Appeal Decision

Appeal Ref: APP/R5510/W/22/3296173

16 Swanage Waye, Hayes UB4 0NX

- The appeal is made under section 78 of the Town and Country Planning Act 1990 against a refusal to grant planning permission.
 - The appeal is made by Mr Sohail Khan against the decision of London Borough of Hillingdon.
 - The application Ref 27066/APP/2020/3930, dated 28 November 2020, was refused by notice dated 24 February 2022.
 - The development proposed is part two storey, part single storey side/rear extension, a hip to gable conversion, a rear dormer extension and 3 x front roof lights, a single storey front extension and front canopies and conversion of the dwelling into two x two-bedroom flats, including the installation of a new vehicle crossover.
-

DRAWING NO.
109/PP/014

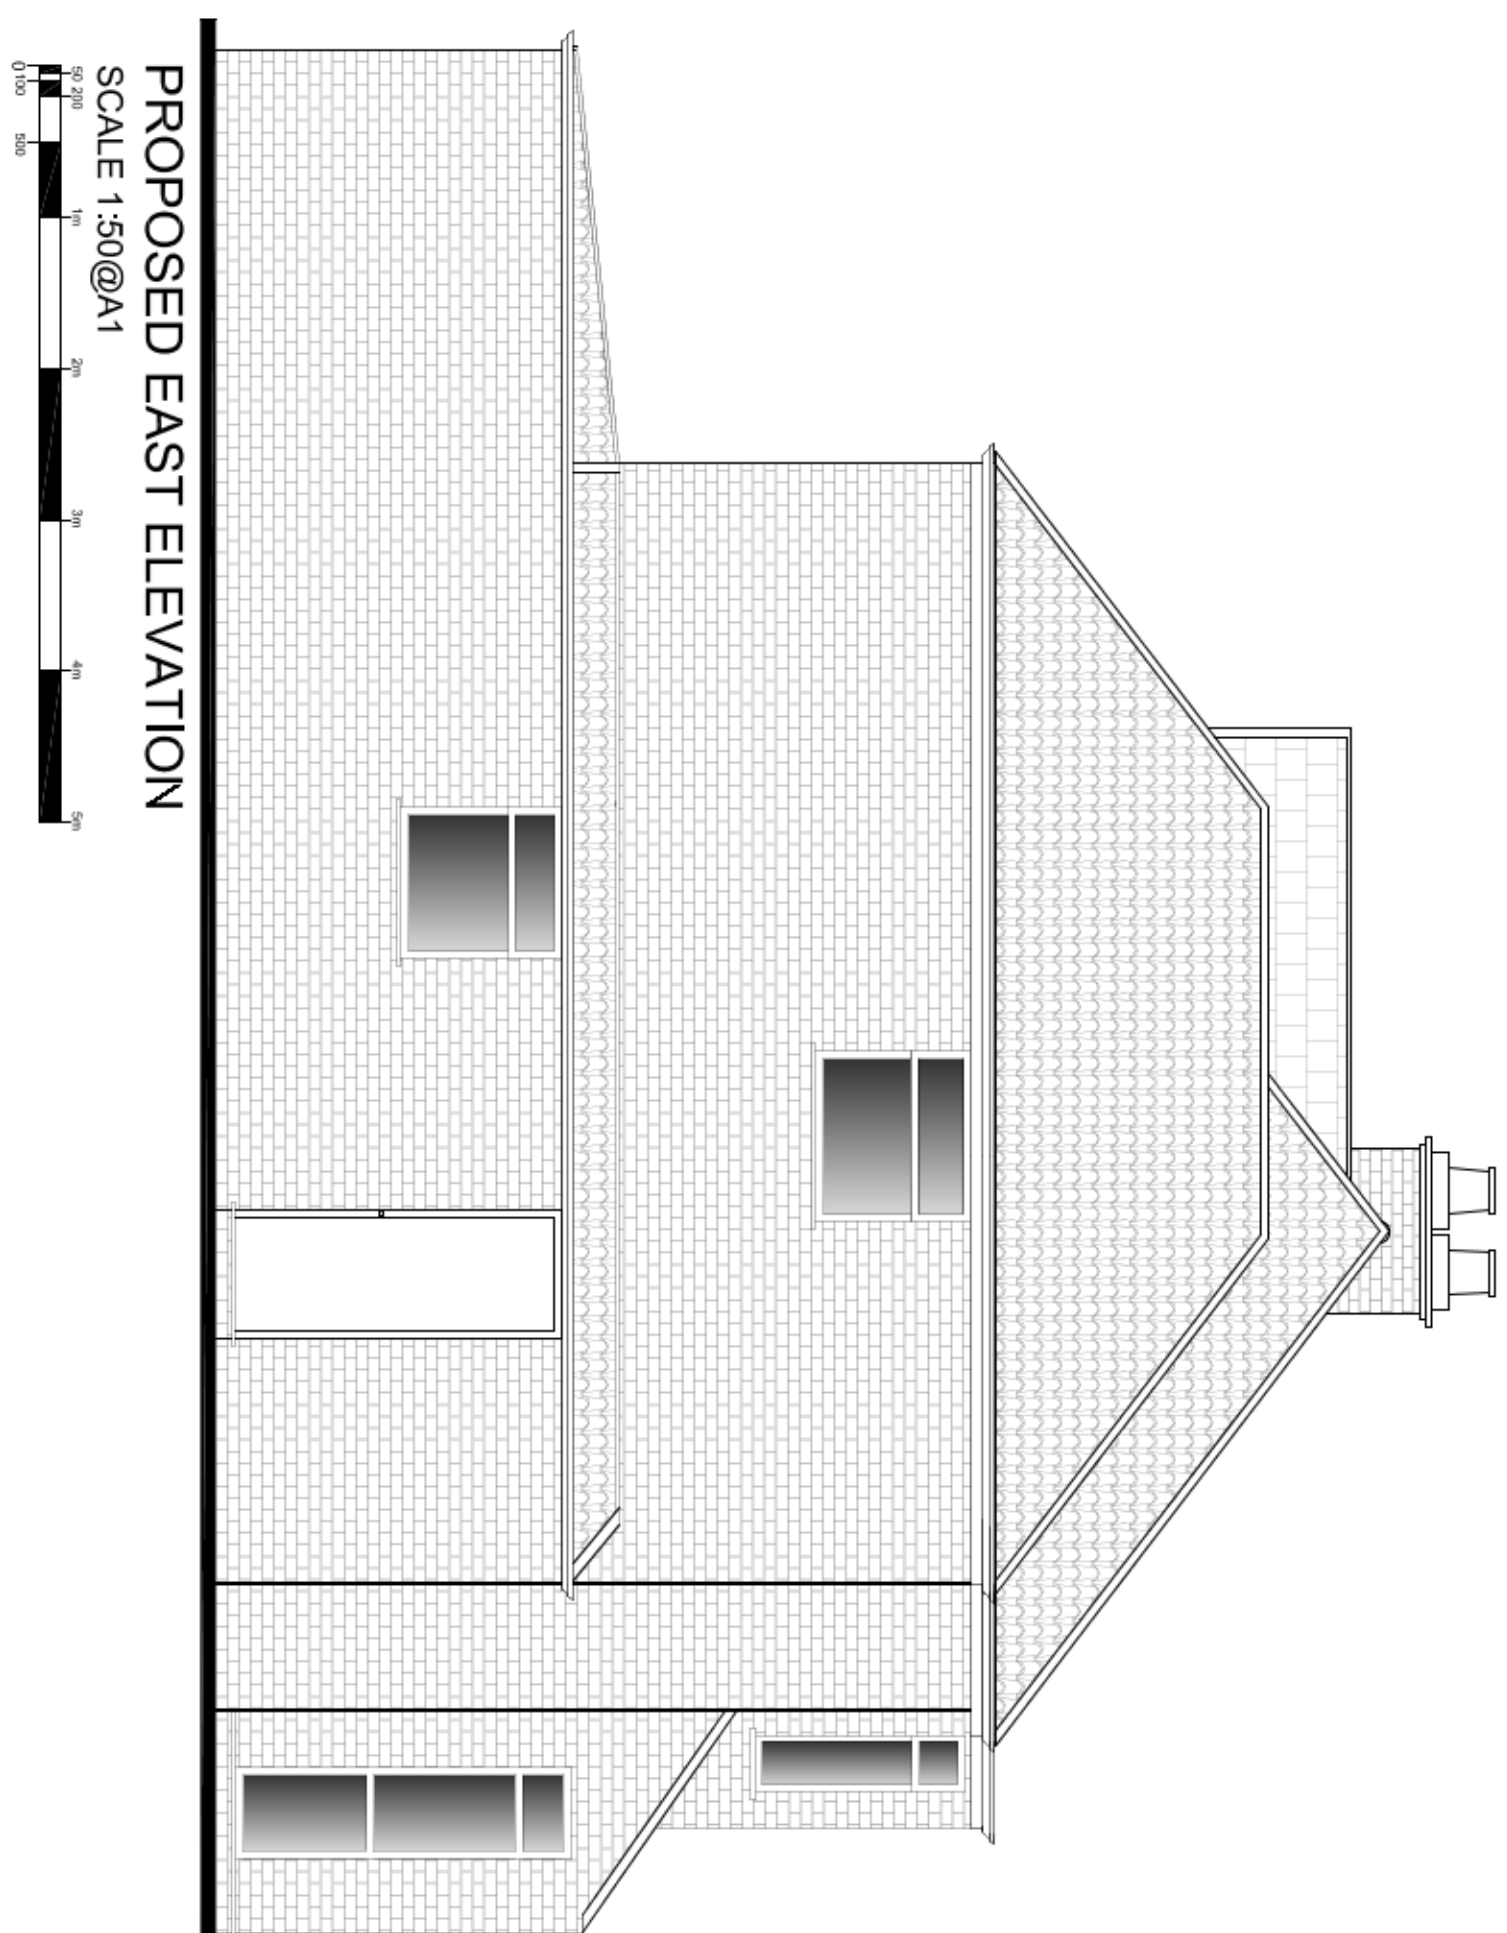
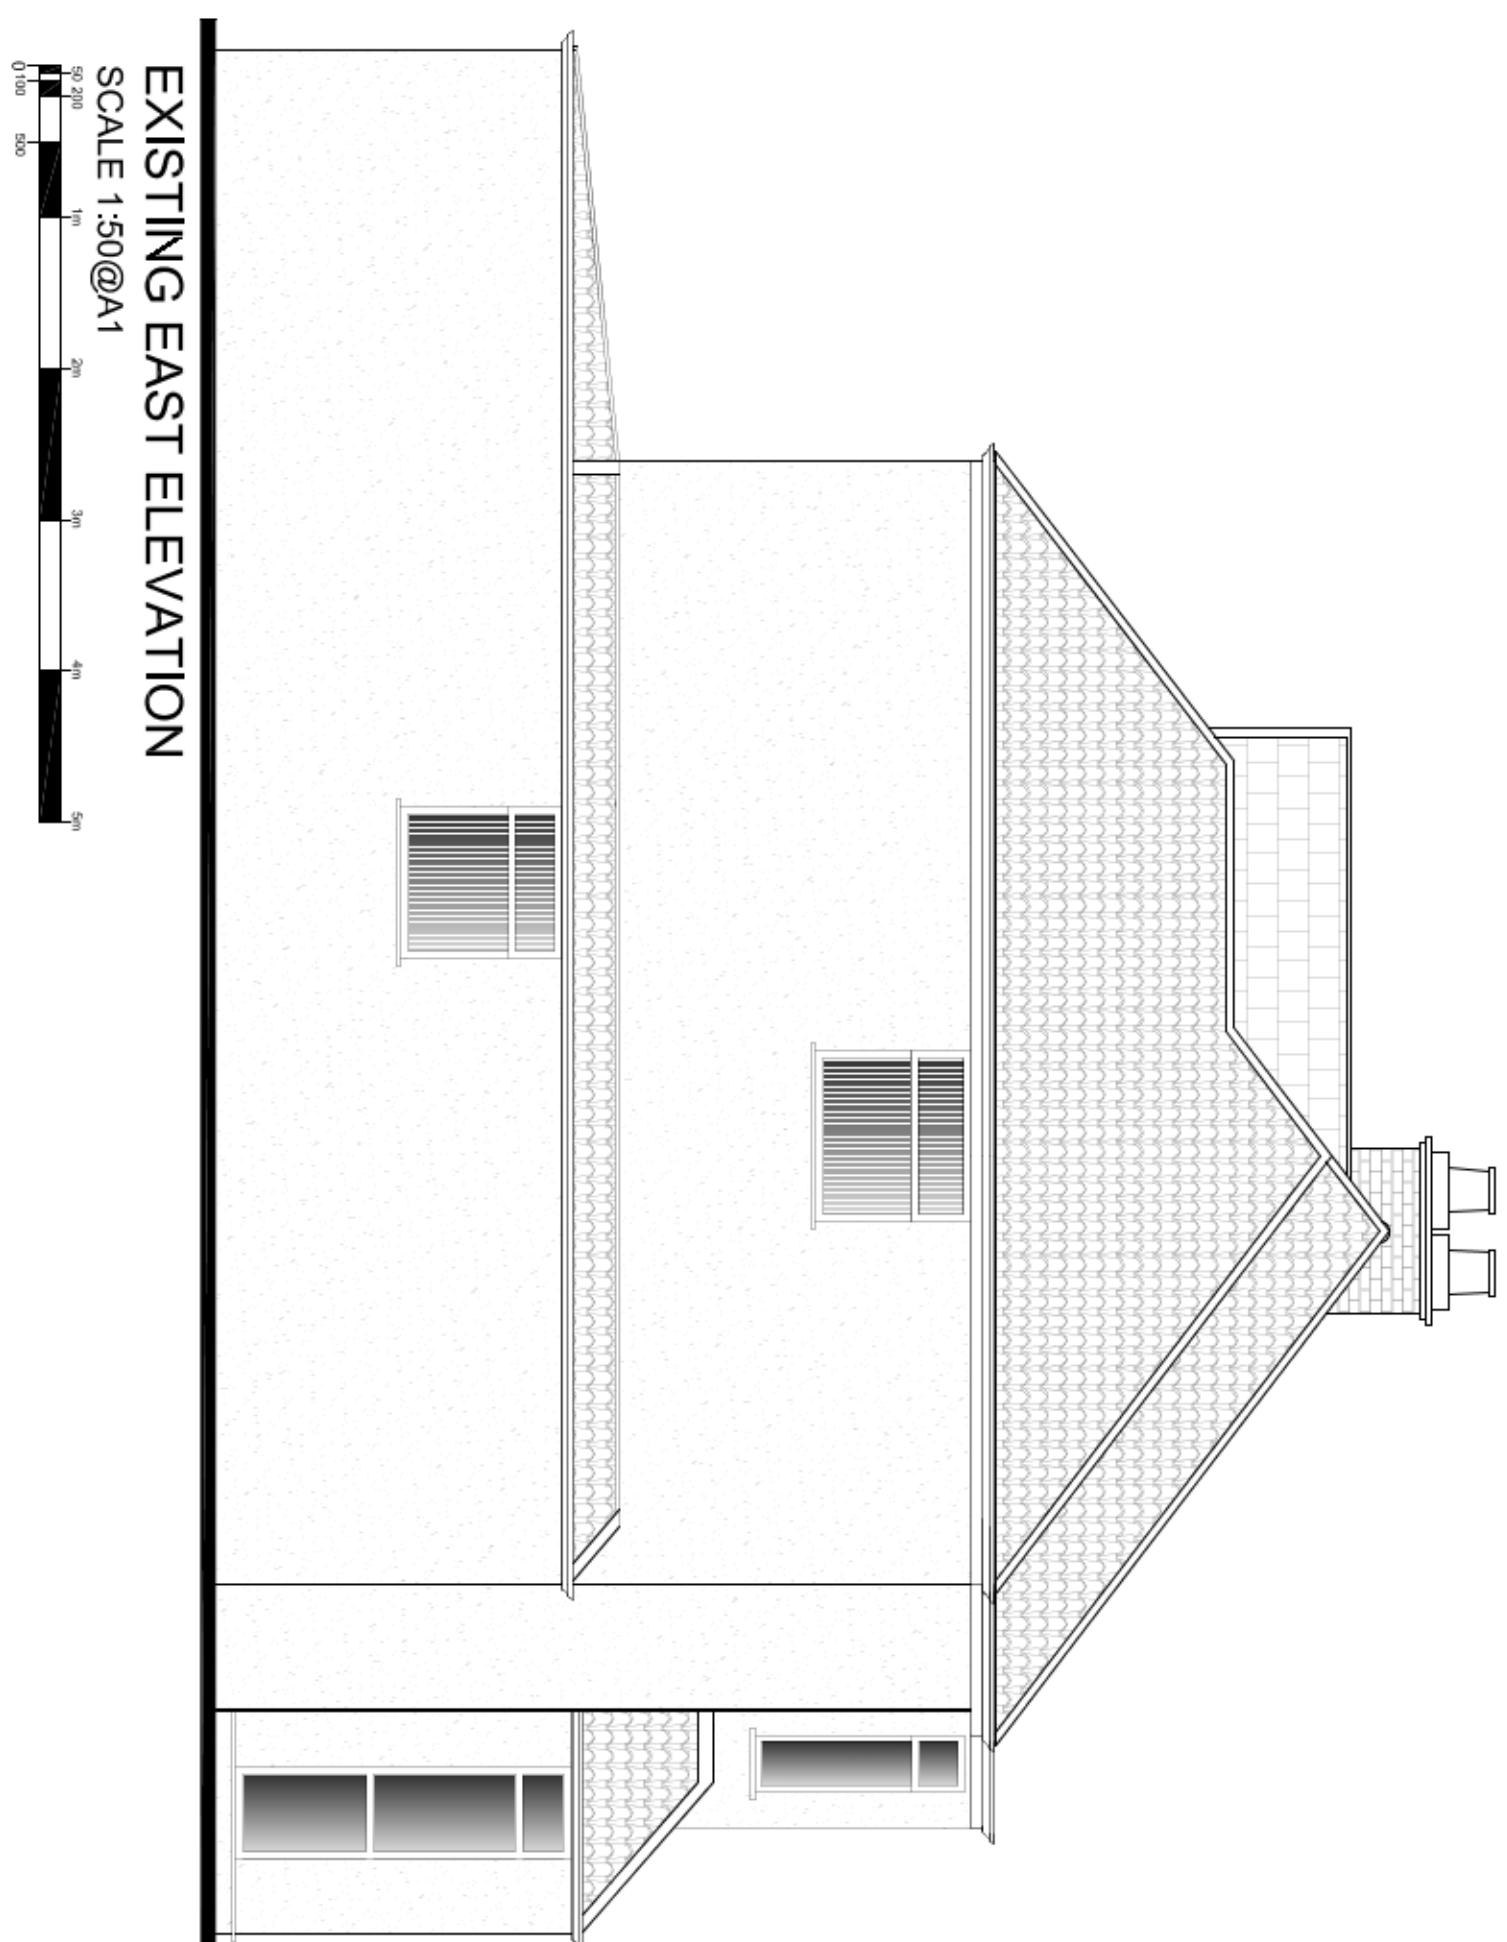
7. The proposed alterations to the front elevation, including a front canopy, appear as intrusive additions given the scale and positioning and are not in keeping with the architectural style of surrounding properties. The use of materials also differs from surrounding properties and appears discordant within this setting.

8. The proposed roof form of the main building, given its massing and design appear obtrusive. The awkward arrangement where the roof of the side and rear first floor extension meets the main roof and the dormer addition is not sympathetic to the simple uniformed roof styles of the surrounding area.
